Student Accommodation (SSD 9194) - 13-23 Gibbons Street, Redfern - Notice of Exhibition

Thank you for your letter dated 21 January 2019, requesting Transport for NSW (TfNSW) review and comment on the above.

Figure 3.6: Cycleway Map

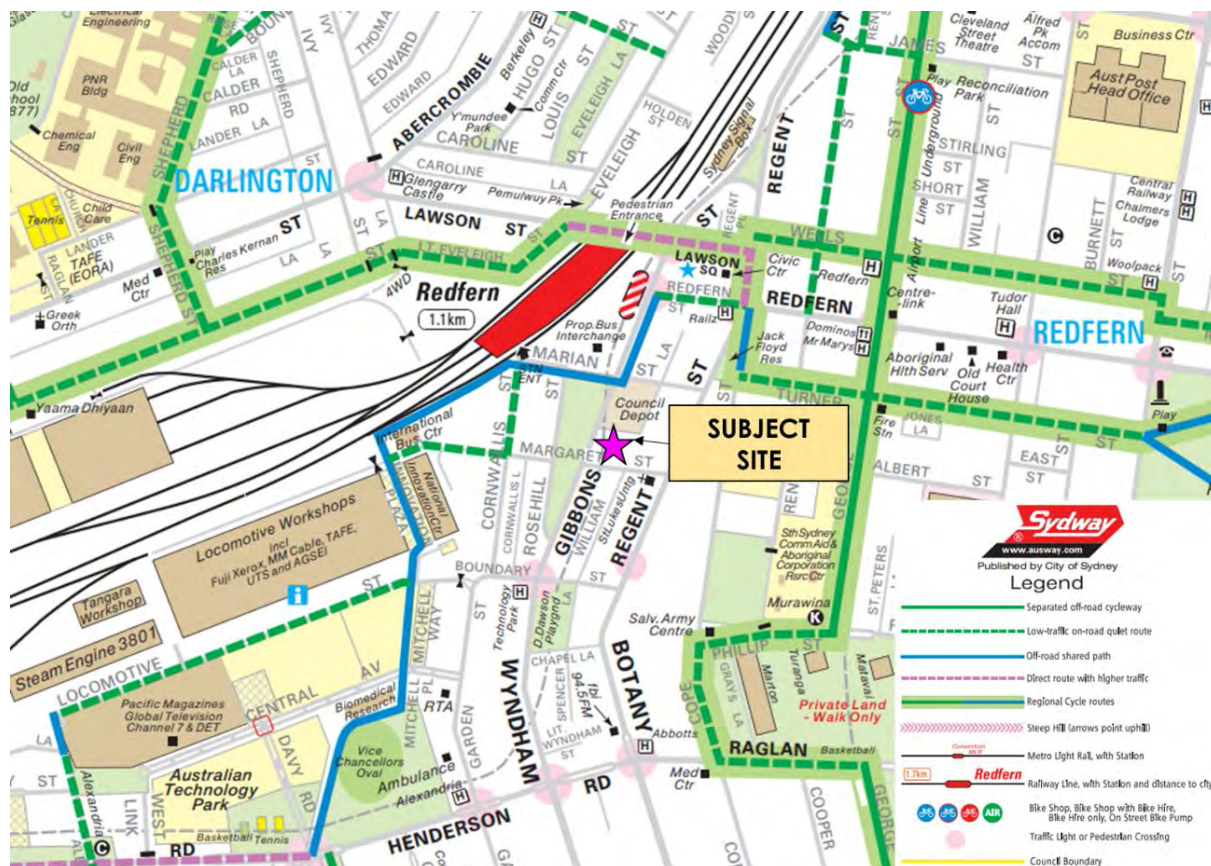
The Traffic Impact Assessment states that bicycle parking area will be provided in the basement level and the bicycle parking/repair areas will be on the ground floor level.

It is advised that the location of bicycle facilities be provided in secure, convenient, accessible areas close to the main entries incorporating adequate lighting and passive surveillance and in accordance with Austroads guidelines.

Figure 3.1: Construction Vehicle Routes

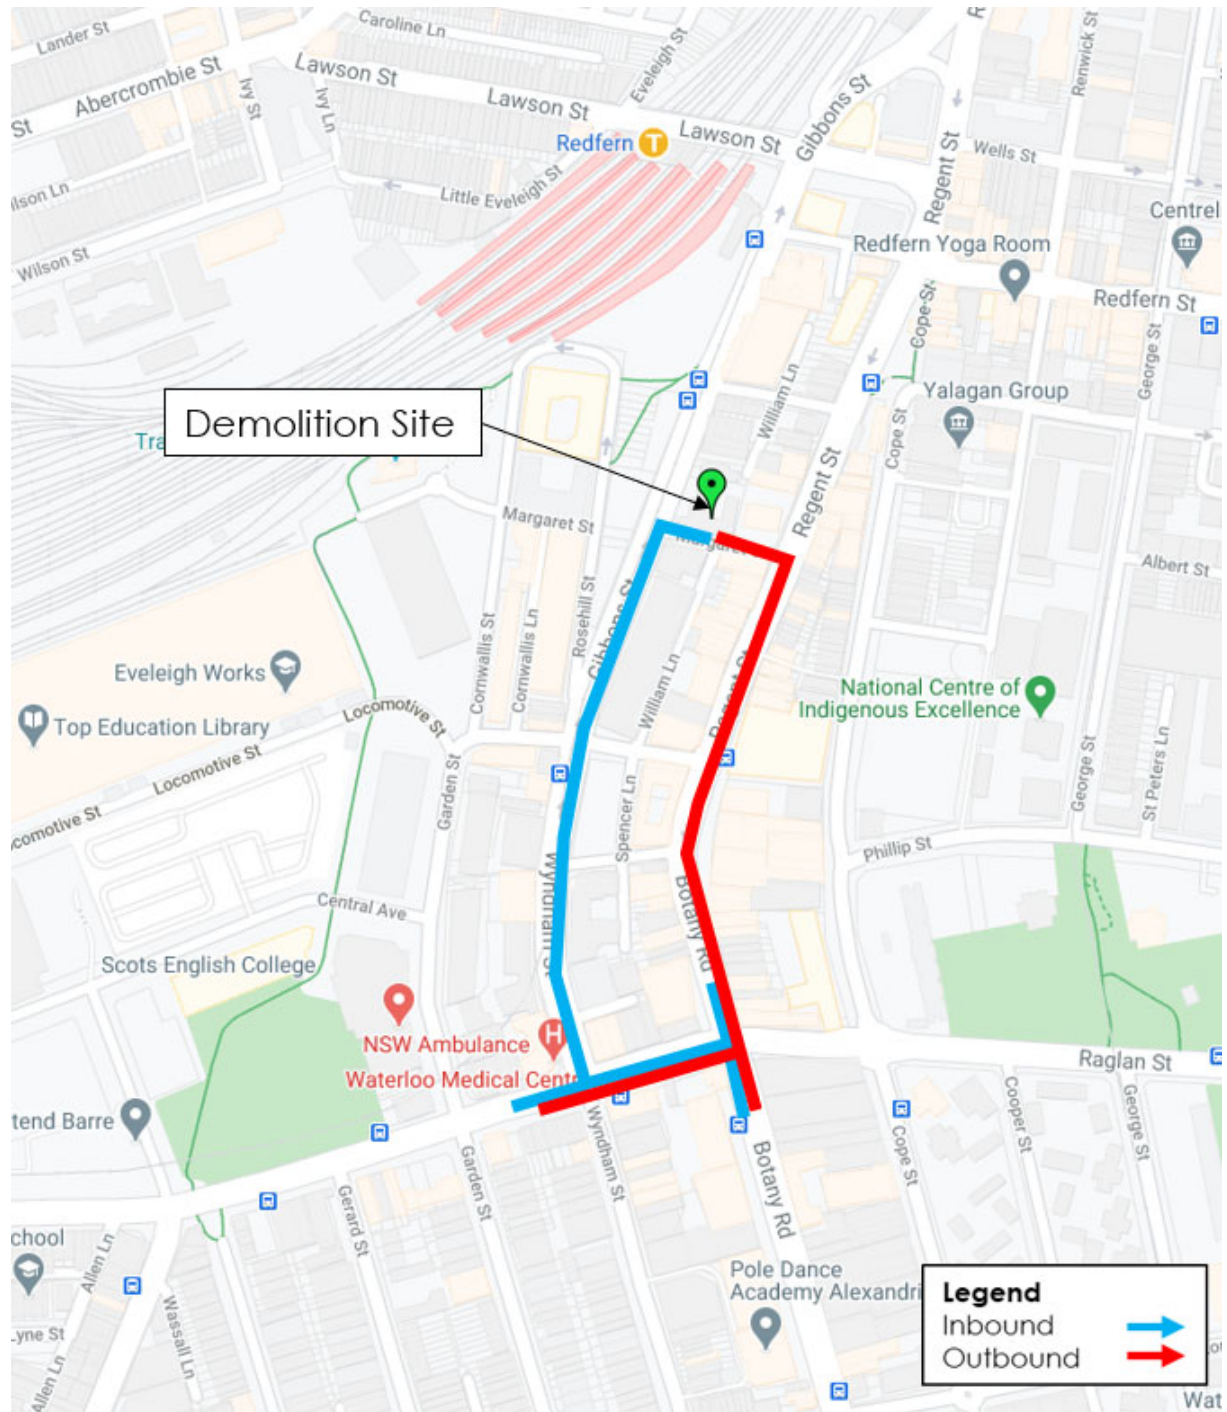
The Construction Pedestrian Traffic Management Plan (CPTMP) prepared to support the development application states that a temporary works zone may be required on Gibbons Street to ensure the safe and efficient operation of construction activities. It is advised that Gibbons Street would not be a suitable location for a work zone during the peak periods due to the following reasons:

- Gibbons Street is a key northbound bus corridor in Redfern with a clearway restriction in place during the morning and afternoon peak periods between Marian Street and Margaret Street on the eastern side of the Gibbons Street; and
- The operation of a construction work zone on Gibbons Street during the peak periods would have the potential to impact on general traffic and bus operations.

Further, several construction projects, including the Sydney Metro City and Southwest and surrounding developments, are likely to occur at the same time as this development within the vicinity of the site. The cumulative increase in construction vehicle movements from these projects could have the potential to impact on general traffic and bus operations within the vicinity of the site, as well as the safety of pedestrians and cyclists particularly during commuter peak periods.

It is requested that the applicant be conditioned to update the Construction Pedestrian and Traffic Management Plan (CPTMP) in consultation with the Sydney Coordination Office within TfNSW and Roads & Maritime Services.

- Location of the proposed work zone , noting that Gibbons Street is not a suitable location during the peak periods;
- Haulage routes;
- Construction vehicle access arrangements;
